Ribble Valley Borough Council
Housing & Development Control

Your ref: 3/2023/0410
Our ref: D3.2023.0410
Date: 9th August 2023

Application no: **3/2023/0410**

Proposal: **New single storey detached building to be used as a fire/stove showroom along with parking spaces.**

Proposed Site Plan 1:200

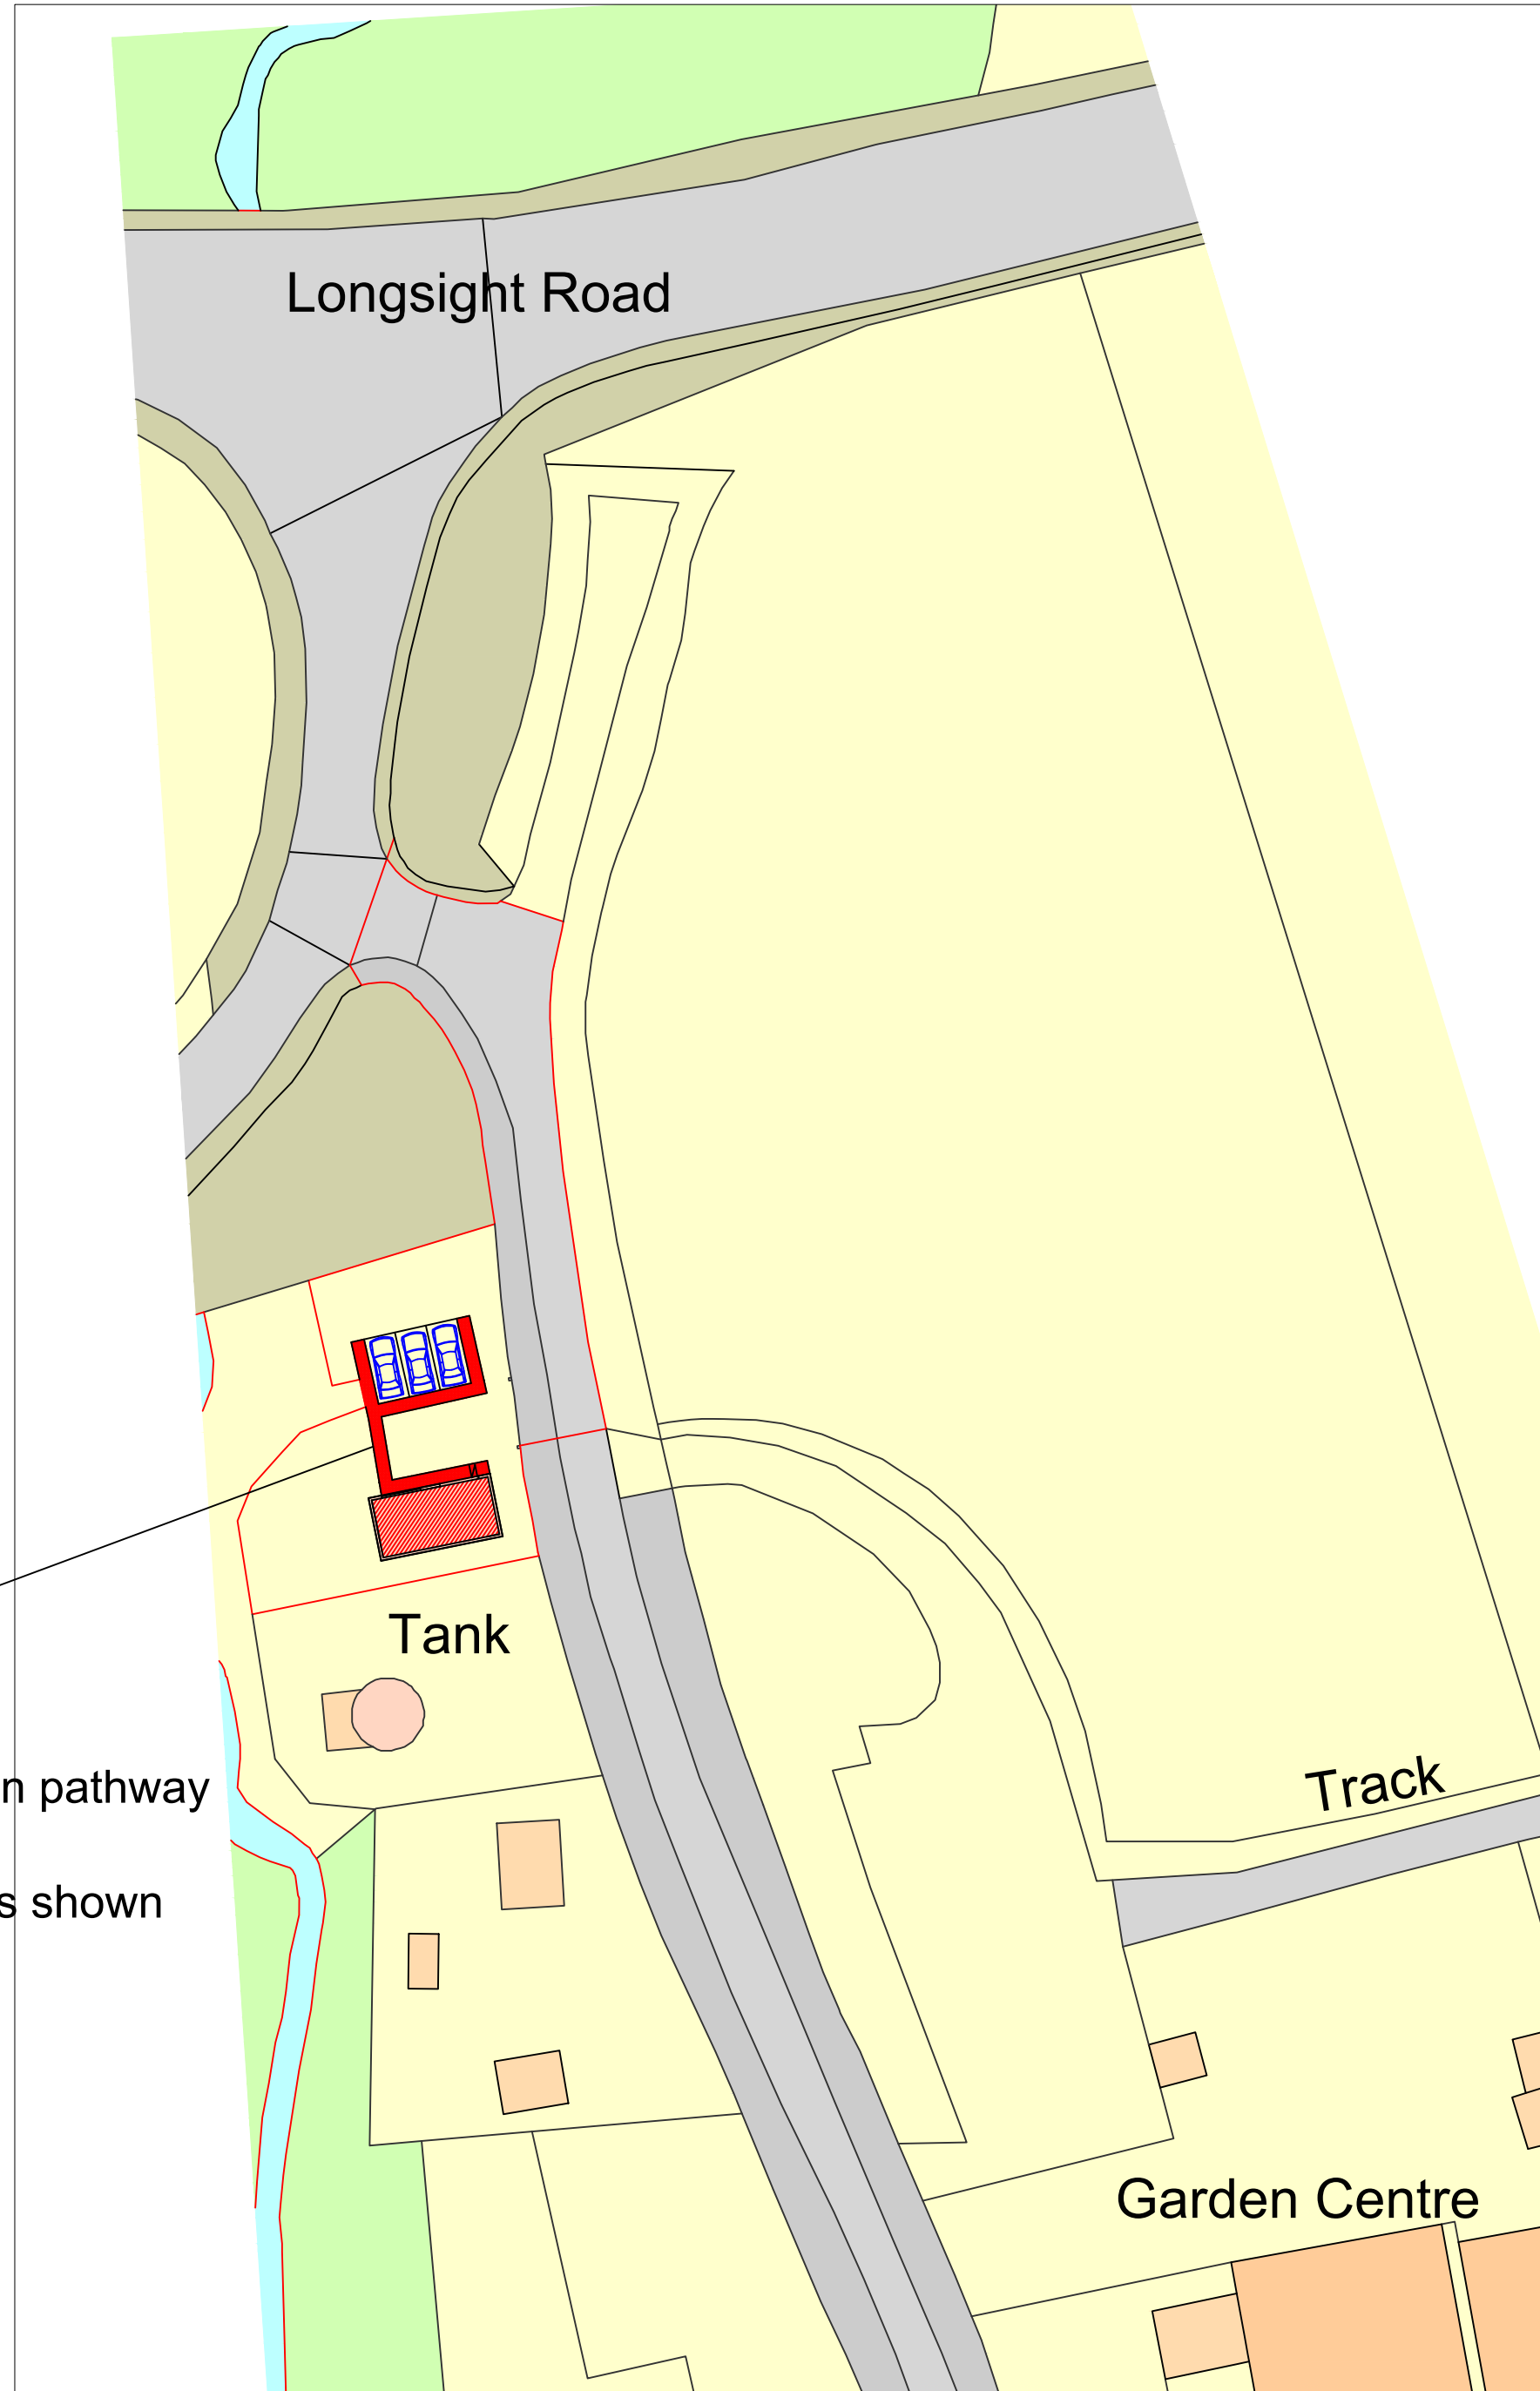
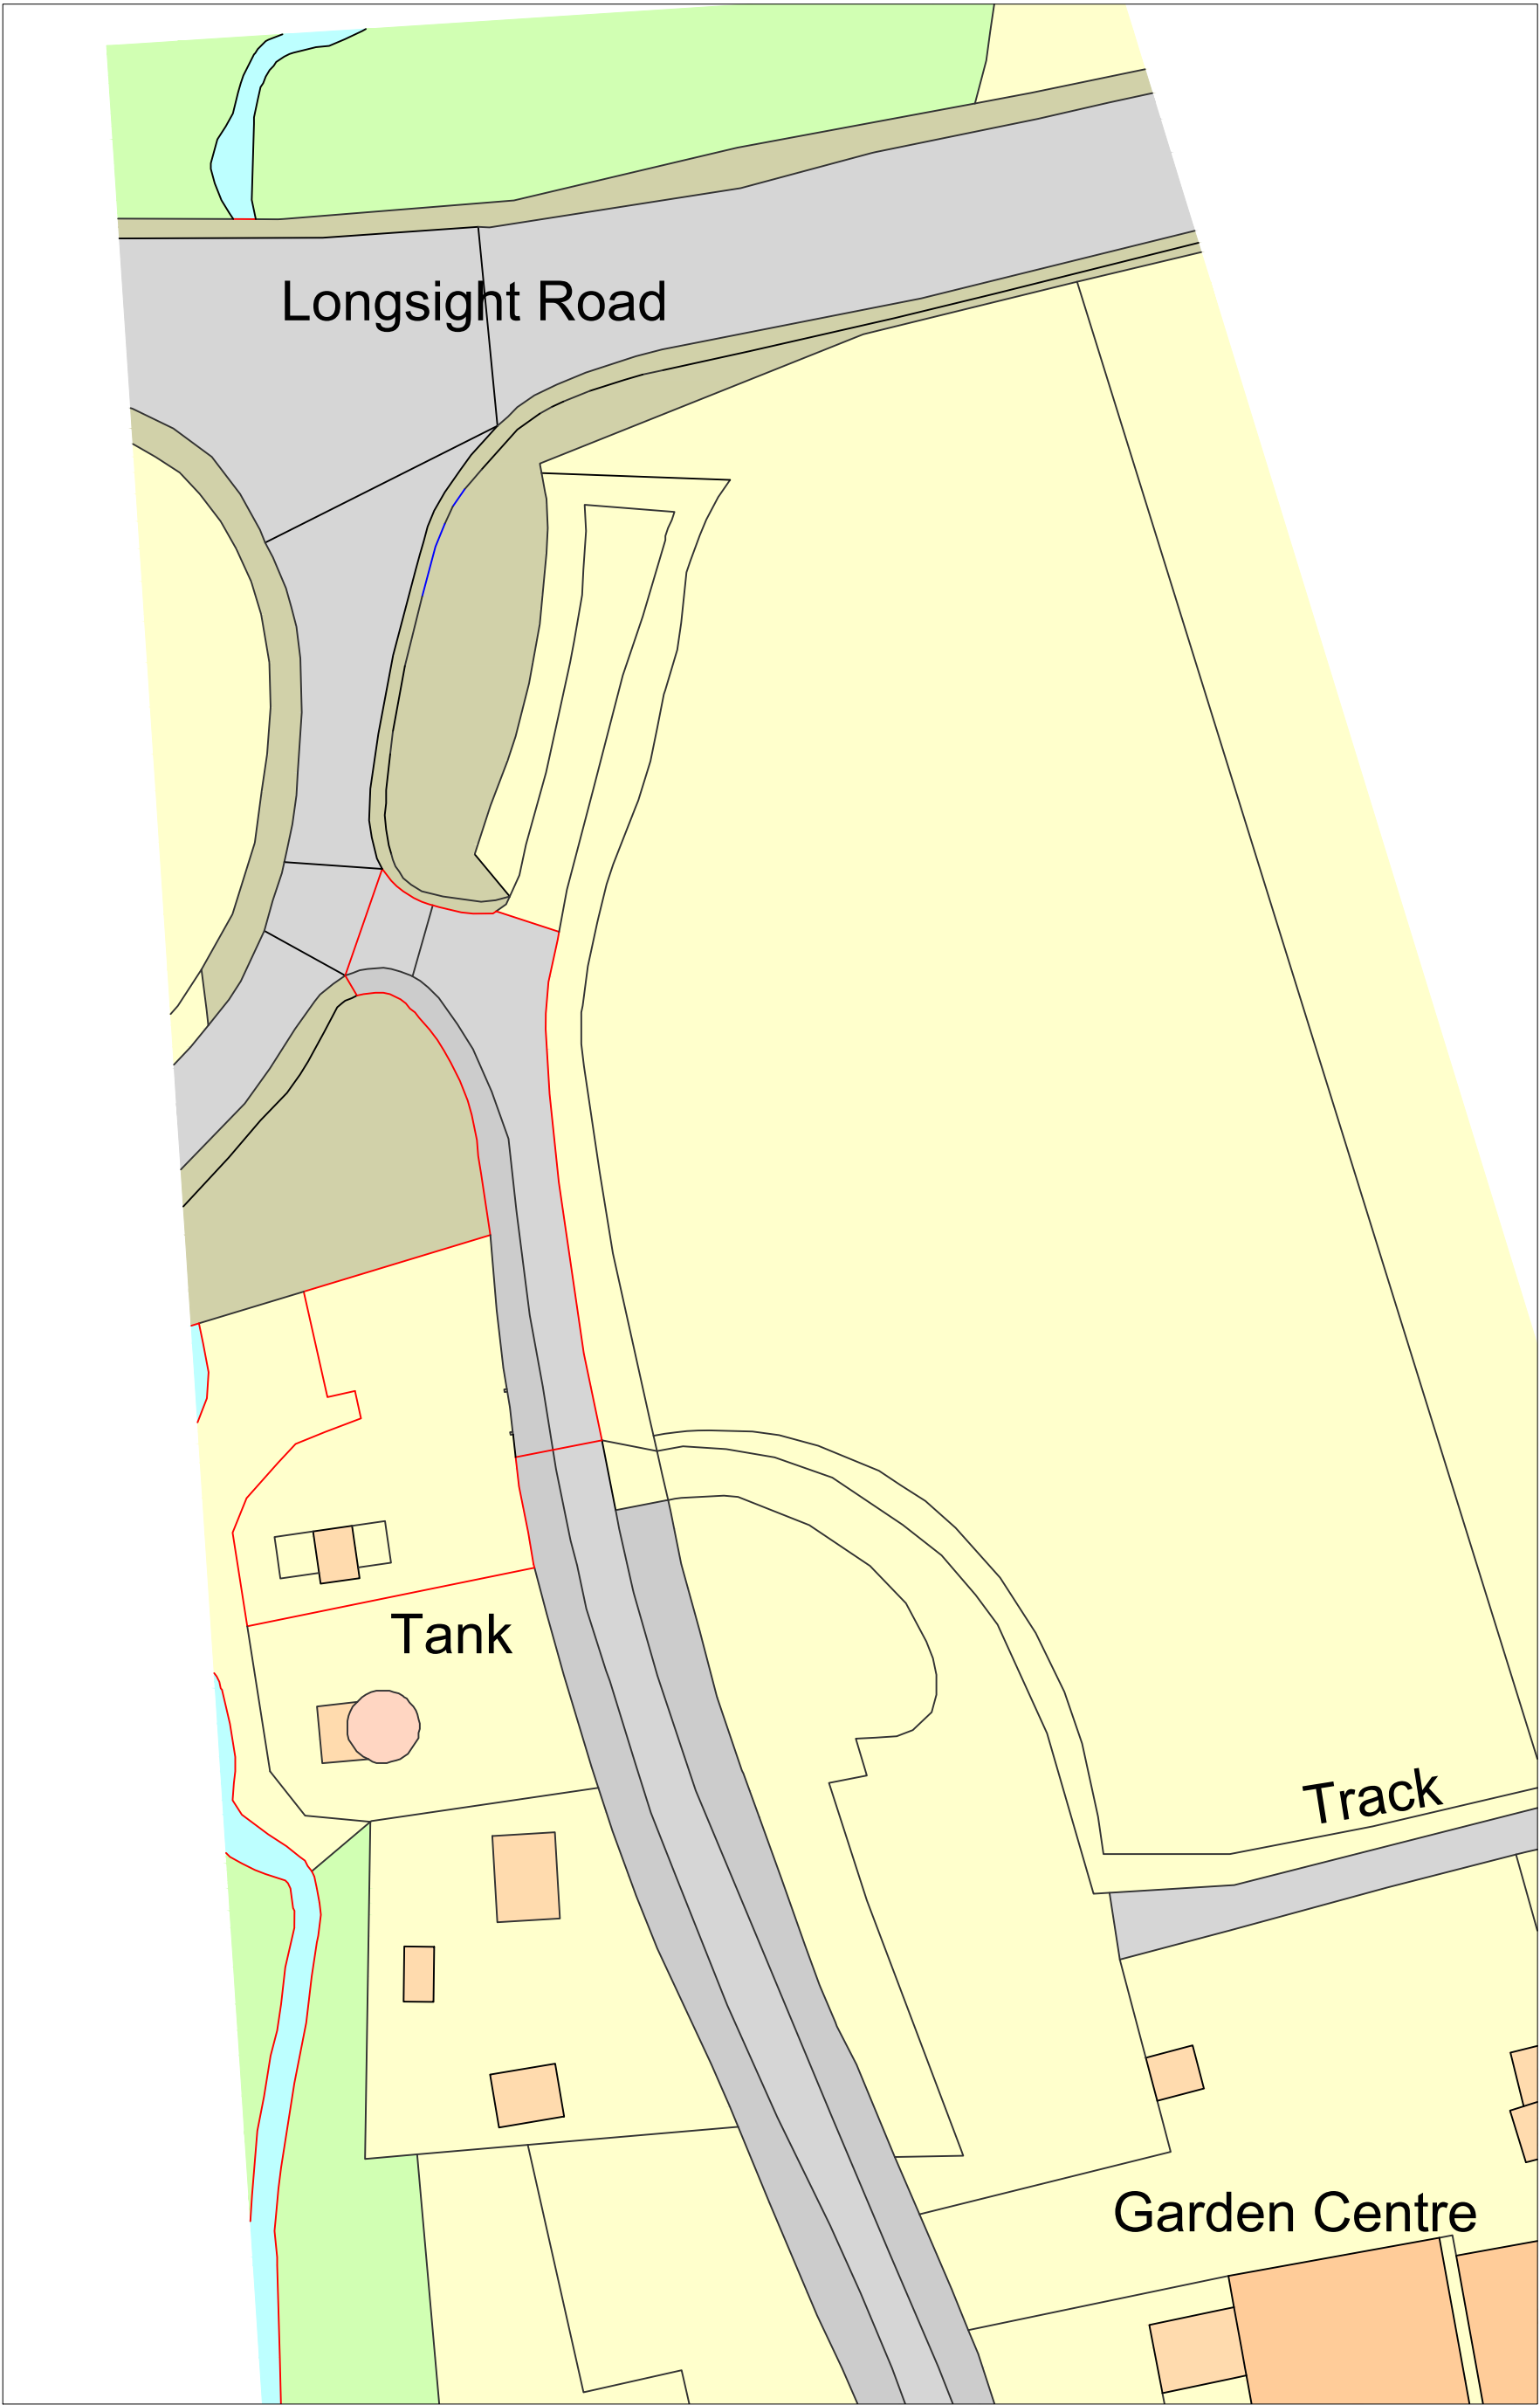
The LHA have reviewed Entwistle Design drawing number 2 of 2 Site Plan Amended 03/08/23 and are aware that the proposal will utilise an existing access to serve the site. The access will be approximately 5.1m wide. However, the LHA require an access serving a commercial unit to be a minimum of 6m wide. Therefore, the LHA require an amended plan showing that the access width complies with the LHAs guidance.

Widening the access will also mean that the existing tree to the left of the access will need to be felled as part of the proposal. Currently, should the access remain as existing, then the tree may conflict with the access's visibility splays, following the intensification of use. Therefore, by widening the access, it will ensure that the access complies with the LHAs guidance but also there will be no conflict with the site's visibility splays.

However, the LHA are aware that the plan has not shown where the site will be serviced from internally but has stated in the Operation Statement that deliveries will be made by transit type vehicles once a week. Due to the infrequency of deliveries, transit type vehicles servicing the site and the LHA likely to condition that customers visit the site on an appointment only basis at a later date, the LHA are satisfied that deliveries can be managed internally without the need for a formalised area.

To ensure that deliveries can occur safely, the LHA will later condition that a servicing plan is submitted prior to occupation.

The LHA require the existing access to be widened to a minimum of 6m wide and the existing tree to the left of the access to be felled as part of the proposal. Should these improvements be shown on an amended plan, the LHA will have no objection to the proposal.
